Active  
Travel  
England

## Active Travel England Planning Response Detailed Response to an Application for Planning Permission

**Application Ref:** 23/01493/REM

**Site Address:** PROPOSED HIMLEY VILLAGE NORTH WEST BICESTER,  
MIDDLETON STONEY ROAD, BICESTER, OX26 1RT

TITLE  
**S278 OFFSITE HIGHWAY WORKS  
 PRIMARY ACCESS JUNCTION  
 GENERAL ARRANGEMENT  
 SHEET 1**

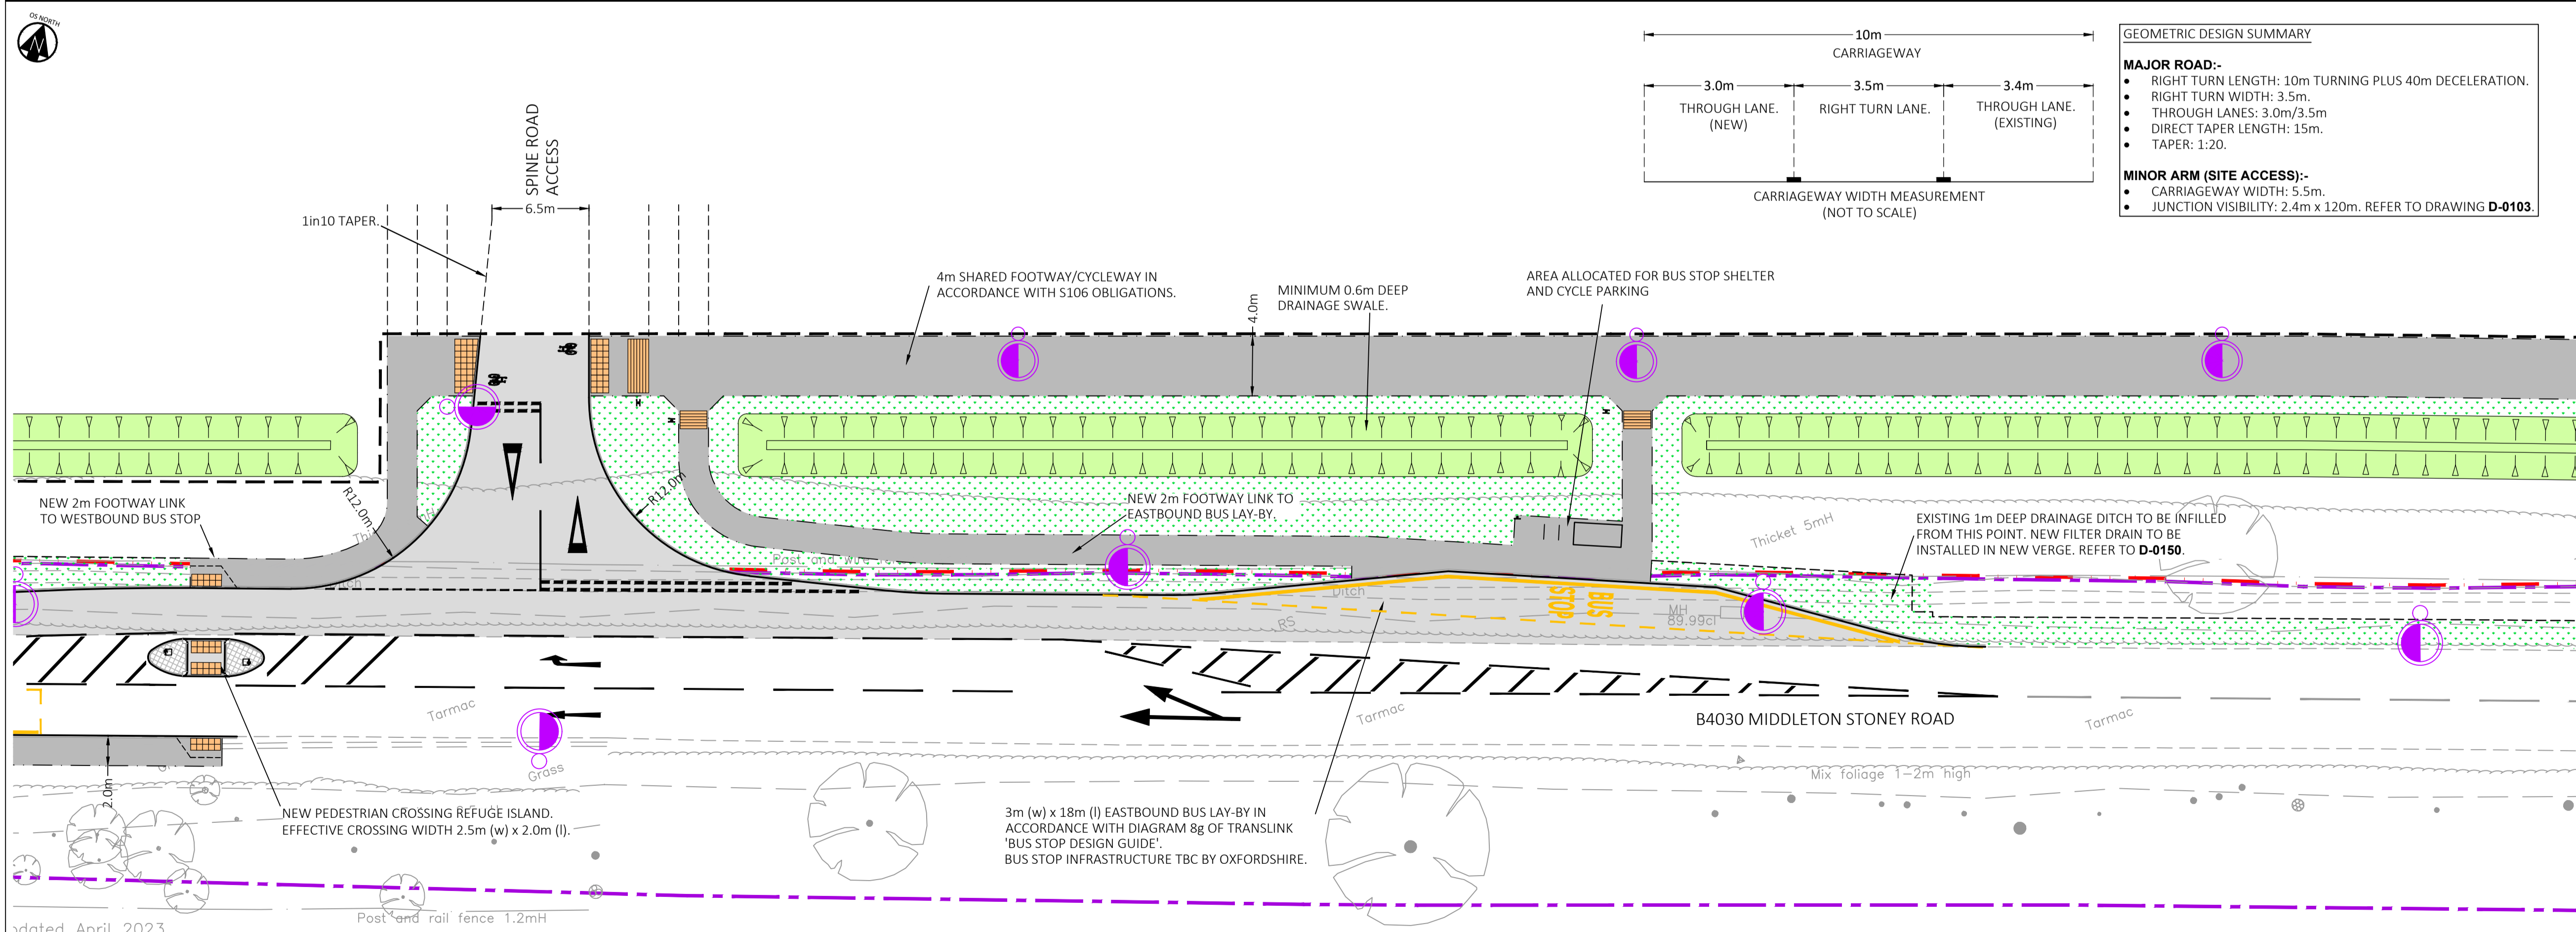
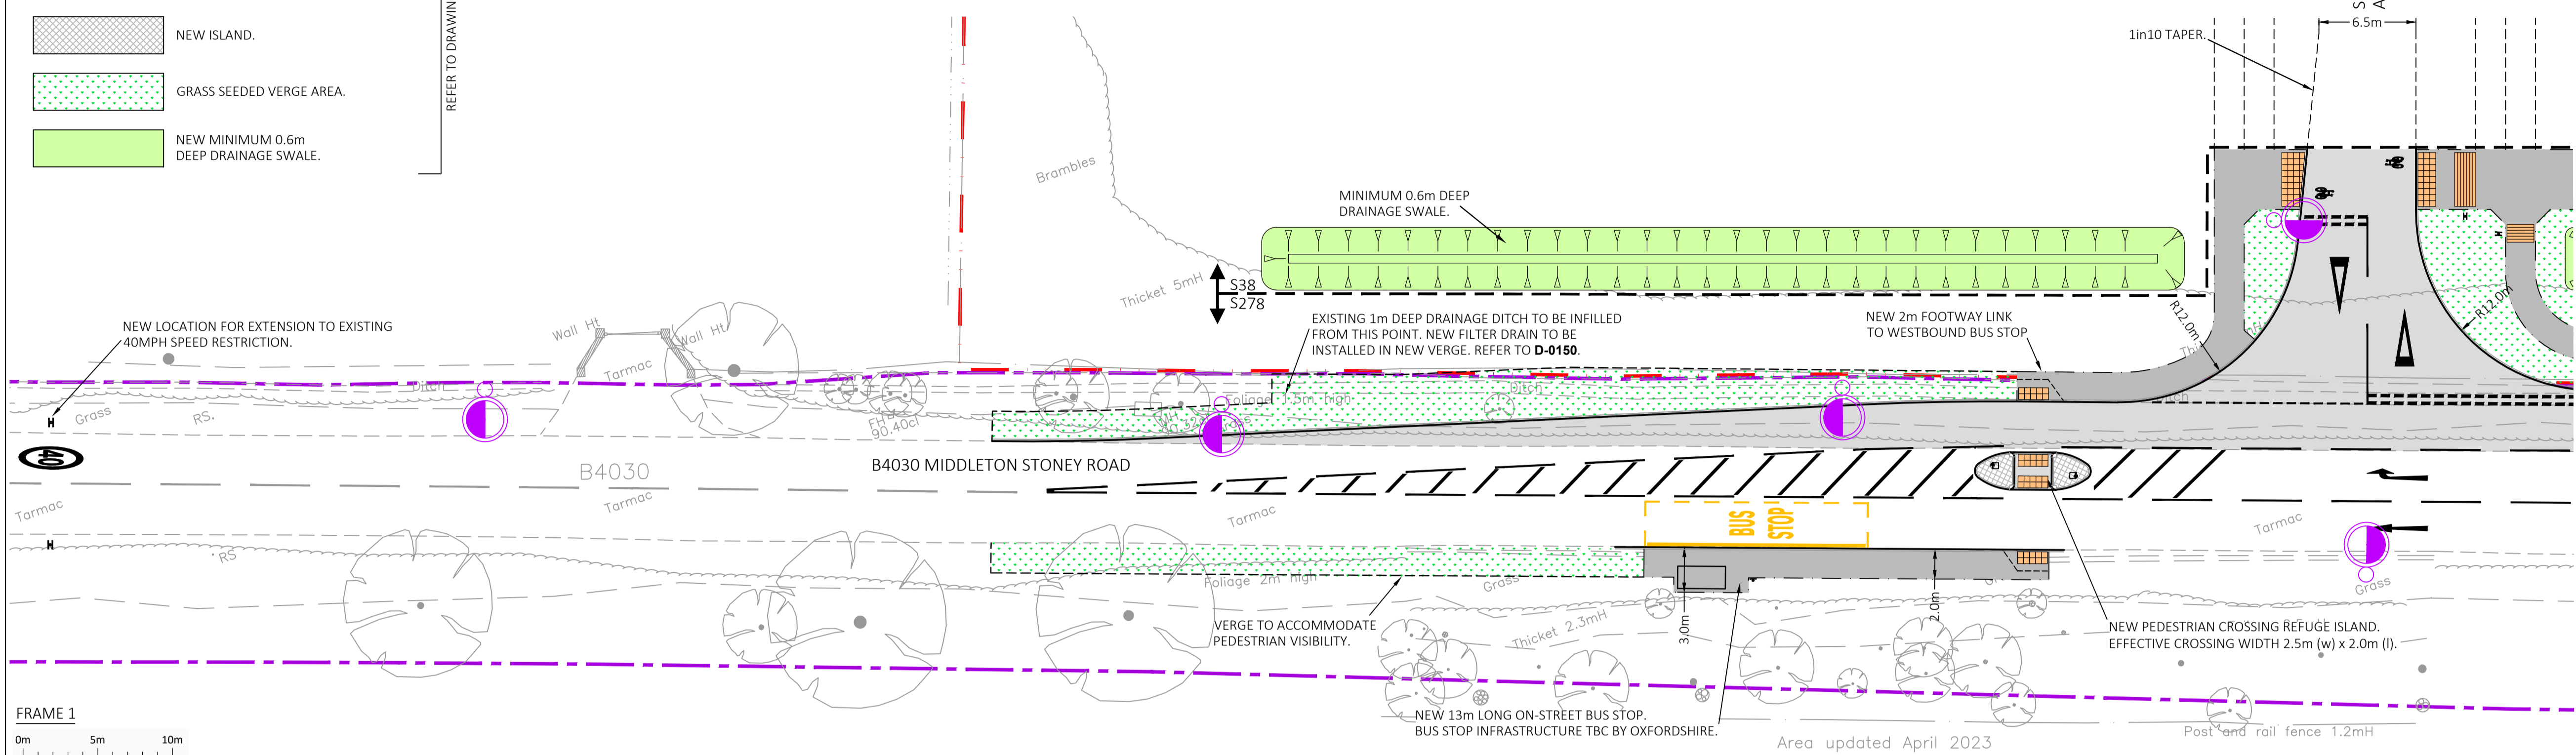
- Apply the same priority arrangement at the Primary Spine Road access as at the Secondary Street access.

The introduction of a priority crossing addresses previous comments.

- A cycle priority crossing has been added across the Primary Access Road, consistent with the Secondary Access Road crossing.

ATE welcomes this amendment.

TITLE  
**S278 OFFSITE HIGHWAY WORKS  
PEDESTRIAN/CYCLE LINK  
GENERAL ARRANGEMENT  
SHEET 3**

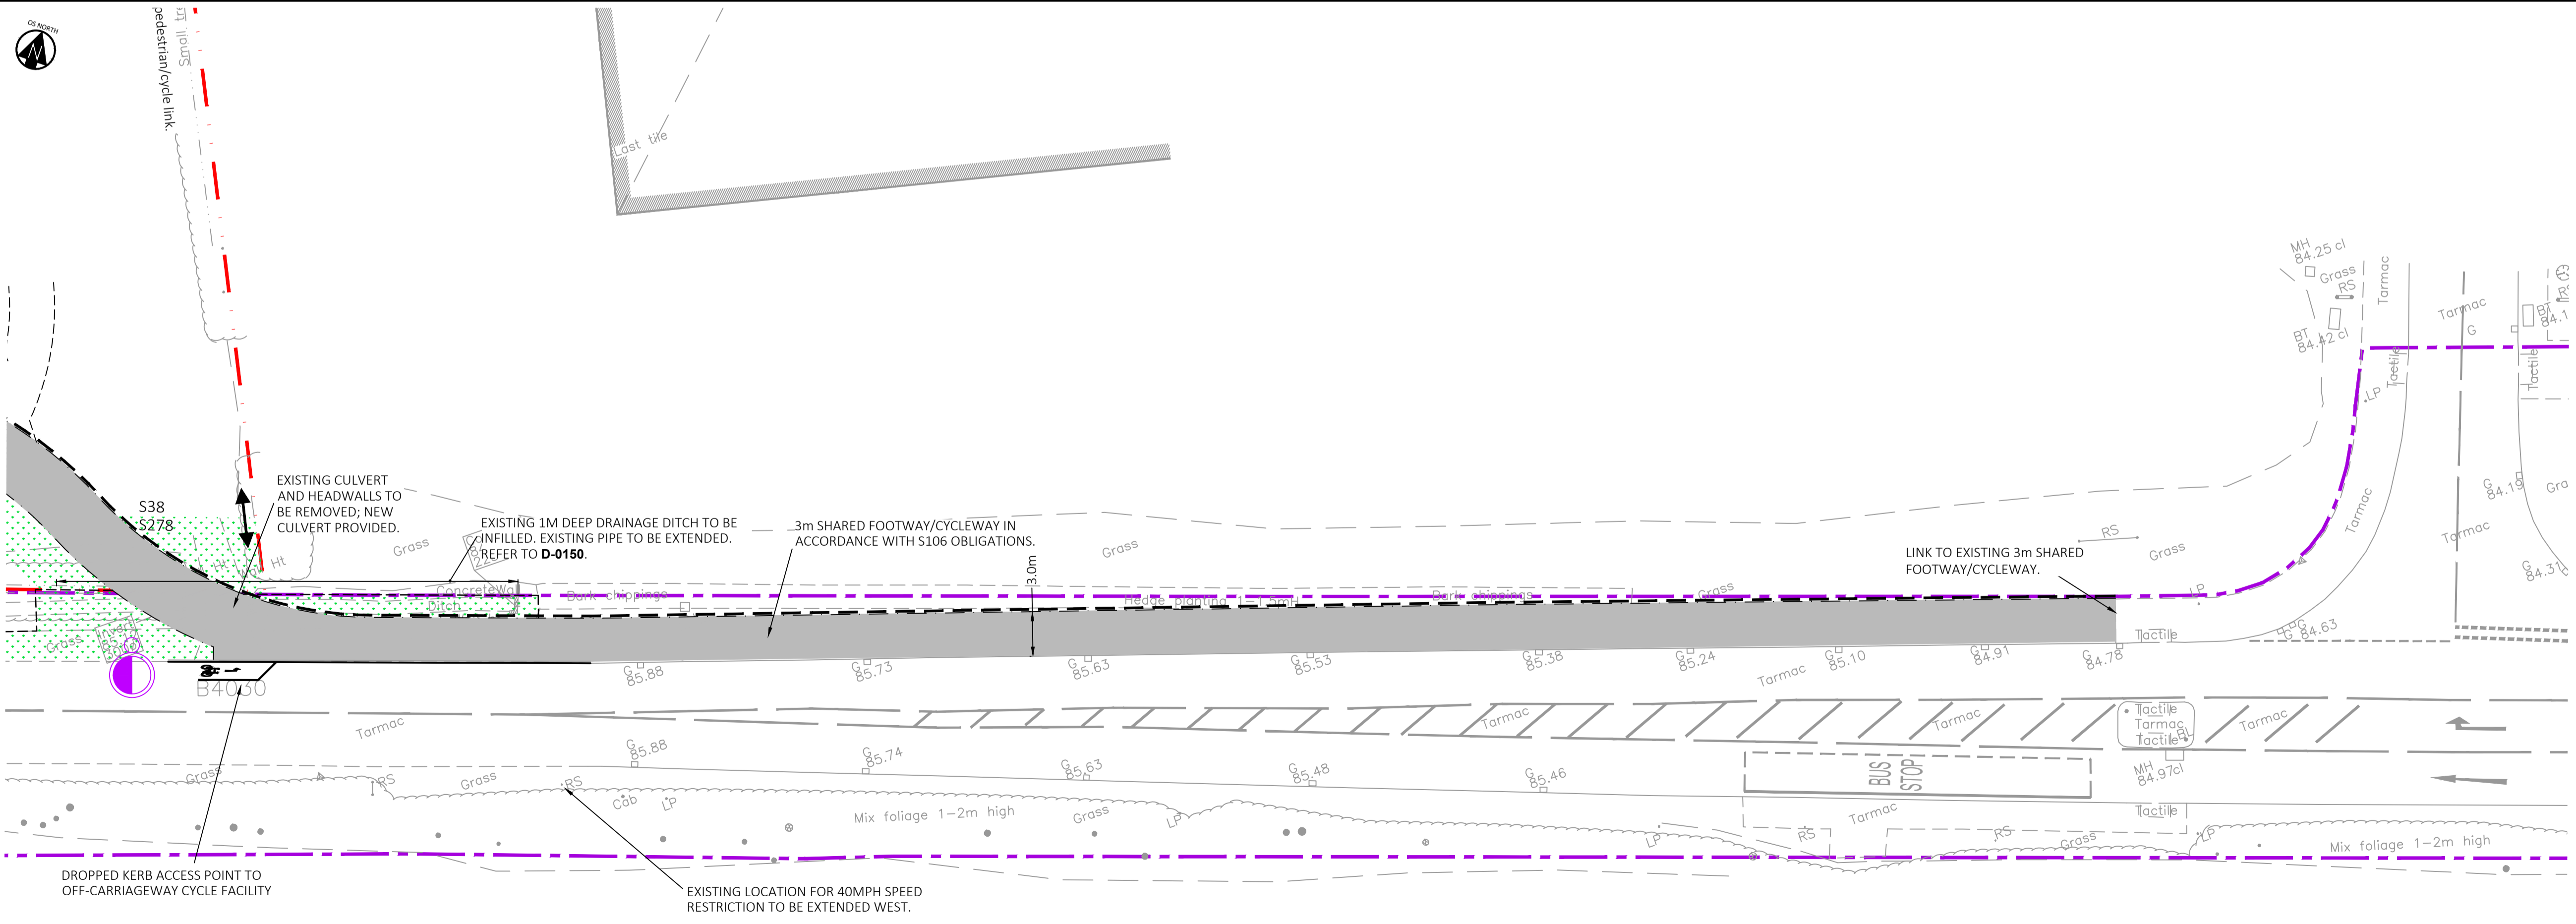
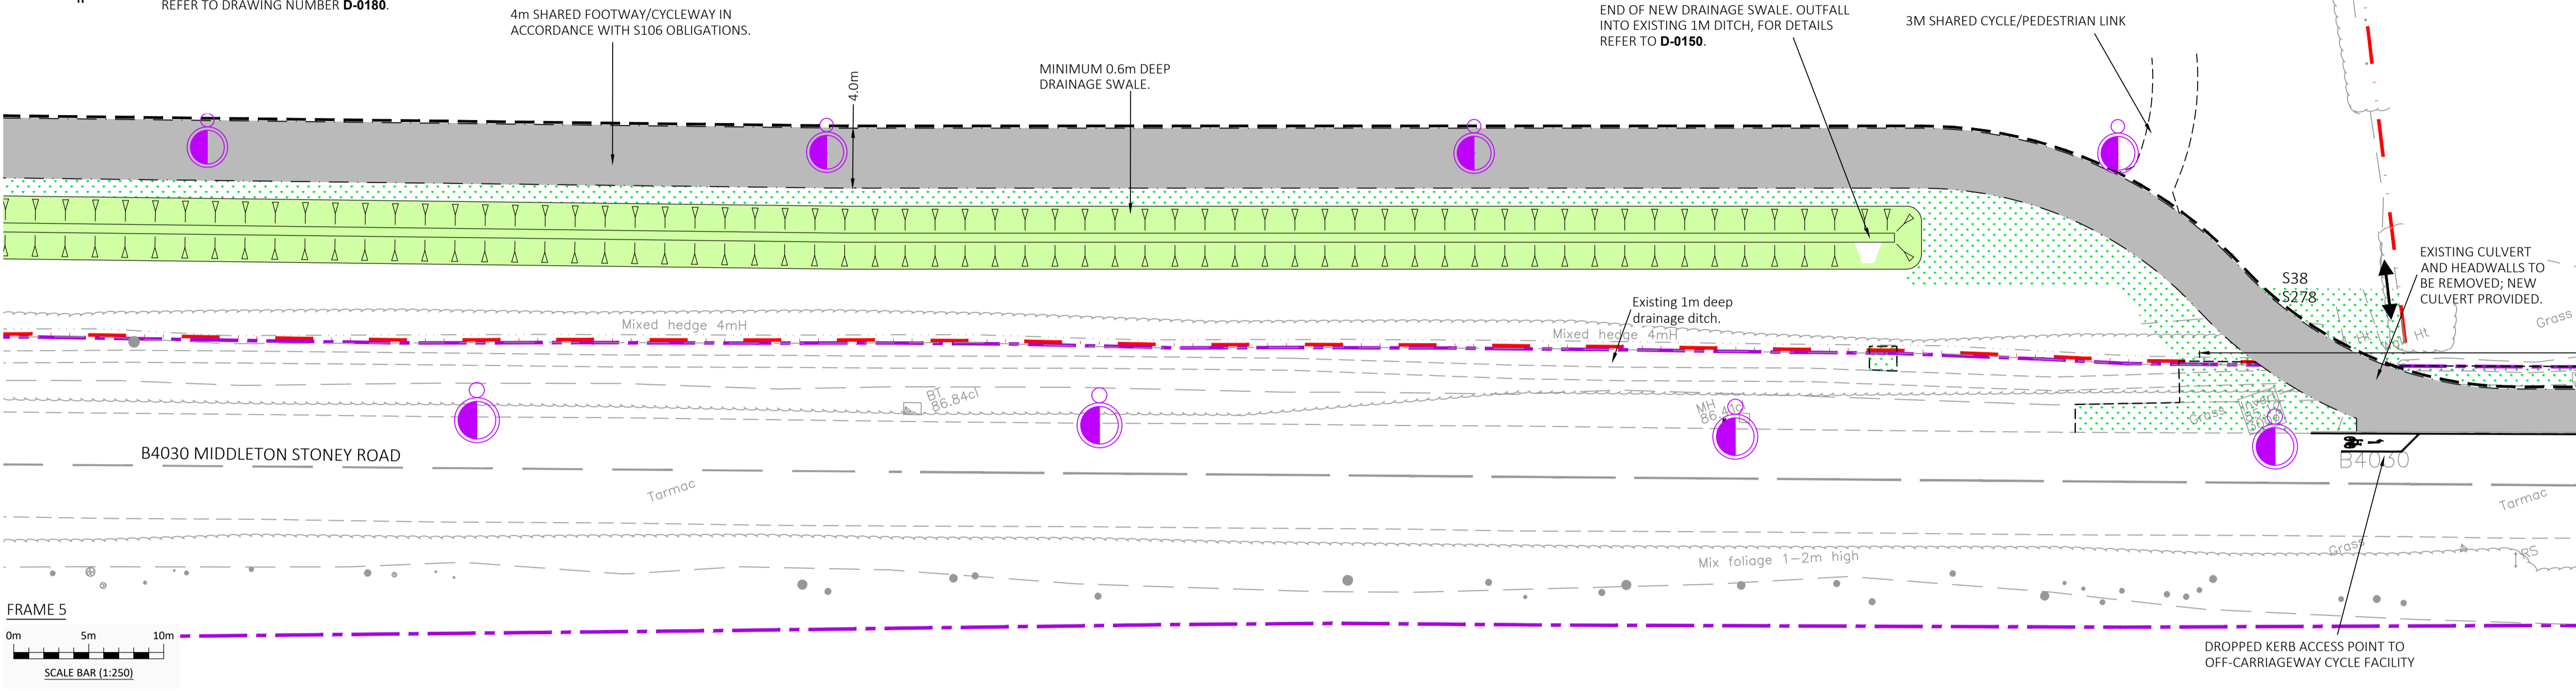
ATE recommended a segregated walking and cycling route along B4030 Middleton Stoney Road to enhance legibility, safety, and attractiveness for walkers and cyclists, in line with Figure 4.1 of LTN 1/20. While shared-use facilities were maintained, the following improvements were implemented:

- A 'lazy S' bend ensures a smooth transition between the on-site 4-m-wide footway/cycleway and the off-site 3-m-wide footway/cycleway.
- A continuous footway/cycleway is provided at the Secondary Street entrance from B4030 Middleton Stoney Road, requiring vehicles to give way.

- Include a buffer between the shared-use path and B4030 Middleton Stoney Road east of the 'lazy S'.

- Regarding the buffer, the applicant cites land ownership constraints.

Whilst this is disappointing, it is noted that the agreed speed limit reduction from 40 mph to 30 mph along this section of B4030 Middleton Stoney Road will lessen the need for a buffer, and the position is accepted.
